Our ref: CE/2007/101068/01-L01
Your ref: 3/2007/0964
Date: 11 December 2007

**PROPOSED B1 OFFICE DEVELOPMENT (REVISION TO APPROVED MATTERS APPLICATION)
BARROW BROOK, OFF A59, BARROW, CLITHEROE**

We **OBJECT** to the proposed development as submitted on the following grounds:-

Schematic Layout 5

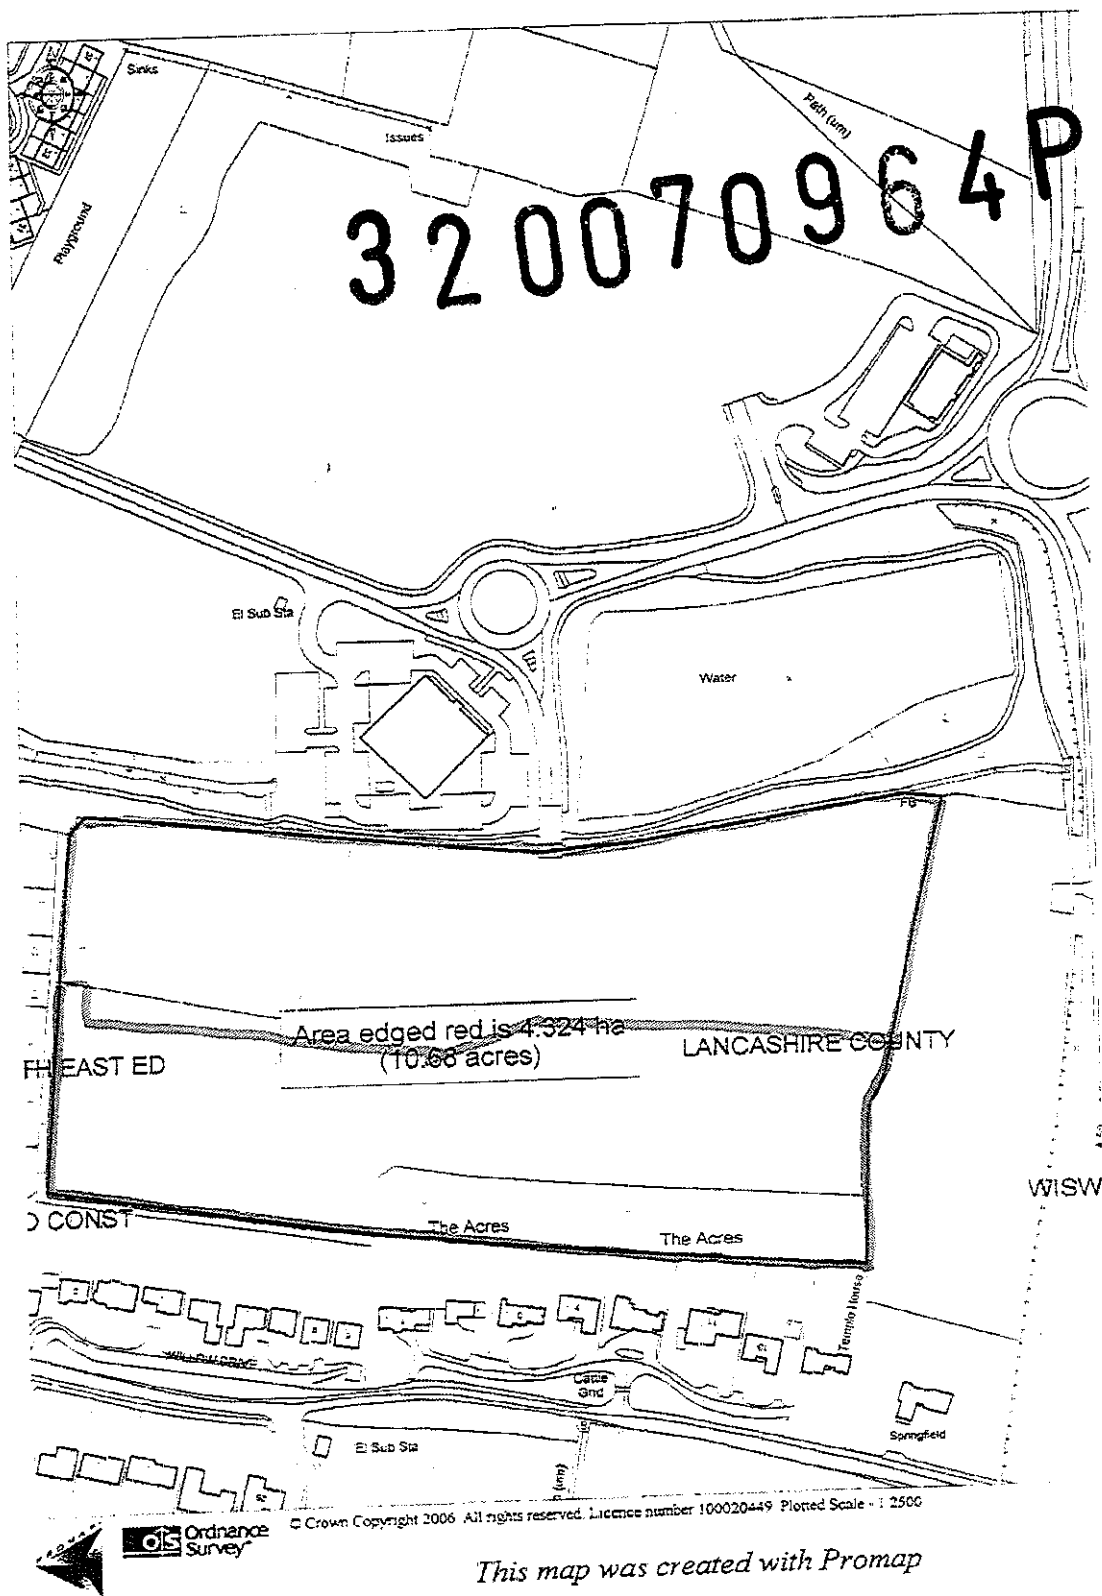
The proposed layout illustrated on drawing number 1302/114E, as prepared by Craven Design Partnership and dated June 2007, appears to indicate that Unit A on both site 1 and site 2, the car park on site 2 and some car parking on site 1 are as close as 3 metres away from the watercourse flowing along the northern edge of the application site. This would adversely affect the biodiversity value of the aquatic habitat on this site.

We are aware that a different layout has previously been approved under application 3/2002/0878, but that layout appears to show a wider easement between the proposed units and the watercourse based on drawing number 2345/L/002A (Levitt Bernstein). It is our opinion that the previously approved scheme is less damaging to the river corridor than the current proposal.

In order to remove this objection the applicant should submit an amended layout of the buildings and car park in order to preserve a naturally vegetated buffer between any part of the development and the watercourse in order to preserve the integrity of the habitat corridor. The width of this buffer strip should be no less than that approved as part of application 3/2002/0878. The vegetation within this buffer should consist of the existing habitats on the site and not contain introduced non-native landscaping.
